Benjamin Stout Real Estate Inc  
Po Box 53798  
Fayetteville, NC 28305

**Re: Status of Permit Application-SFD2006-0072**

James E. Manhart III, R.E.H.S.  
Environmental Health Program Specialist  
Harnett County Department of Public Health

2-A

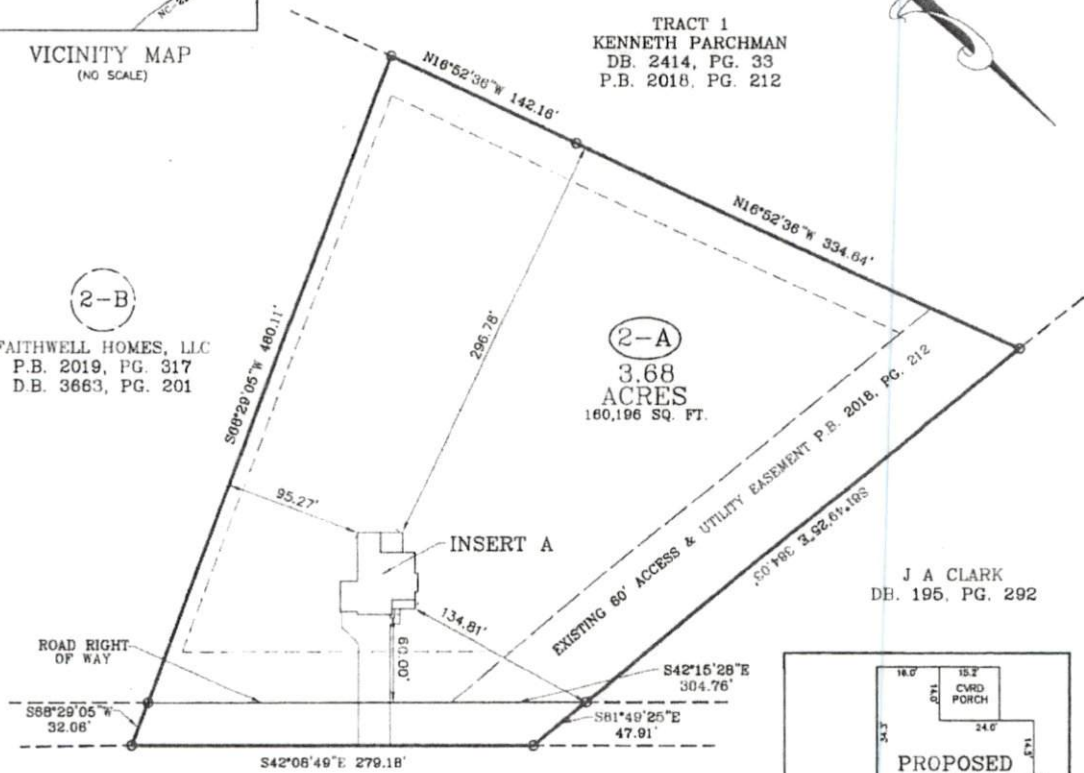
- 1. Use pink flags to mark property lines and irons that are set by surveyor need to be visible. (\$25.00 Fee incurred)
- 2. Use orange flags to mark house box.
- 3. Directions not clear to property (\$25.00 fee incurred)
- 4. Property needs cleared prior to permitting
- 5. Driveway not shown on site plan (Revision Required)
- 6. Backhoe pits maybe required
- 7. Other- Existing septic system on site needs to be located and fully identified.**
